CITY OF PORTLAND

October 16,2001

RE: 229 St. John St. (064 F001)

Please be advised that the permit to install overhead security doors at the above property must be denied. There is insufficient information on the plans submitted to determine that the installation will occur in compliance with the manufacturer's specifications. The construction documents also are incomplete with regard to:

MAKOT PECH MKT
229 St. John St.
Portland ME 04101

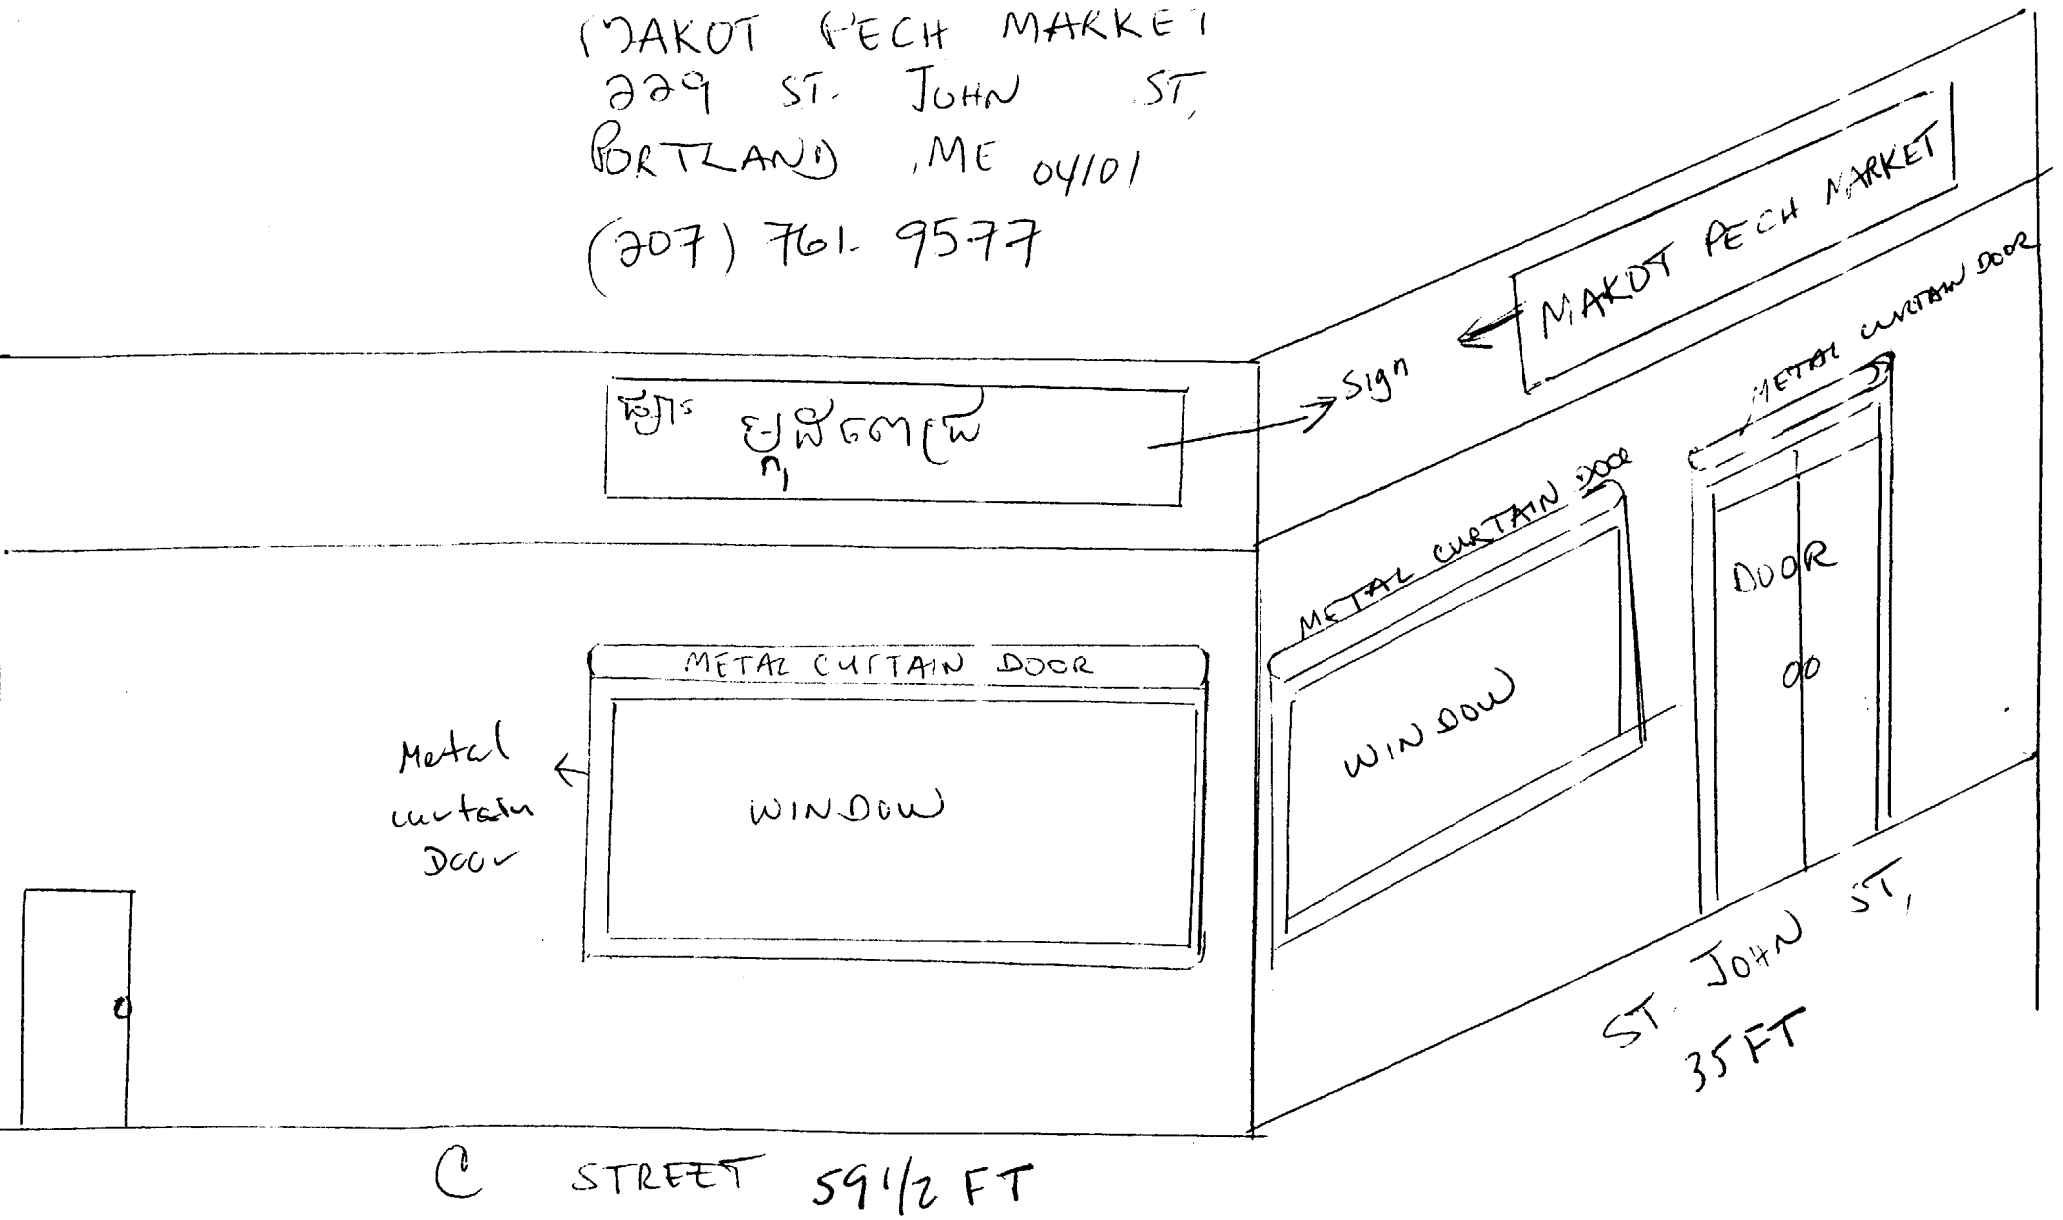
- 1) Construction documents must be provided showing the proposed installation in detail.
- 2) The Manufacturers specific installation instructions and specs.
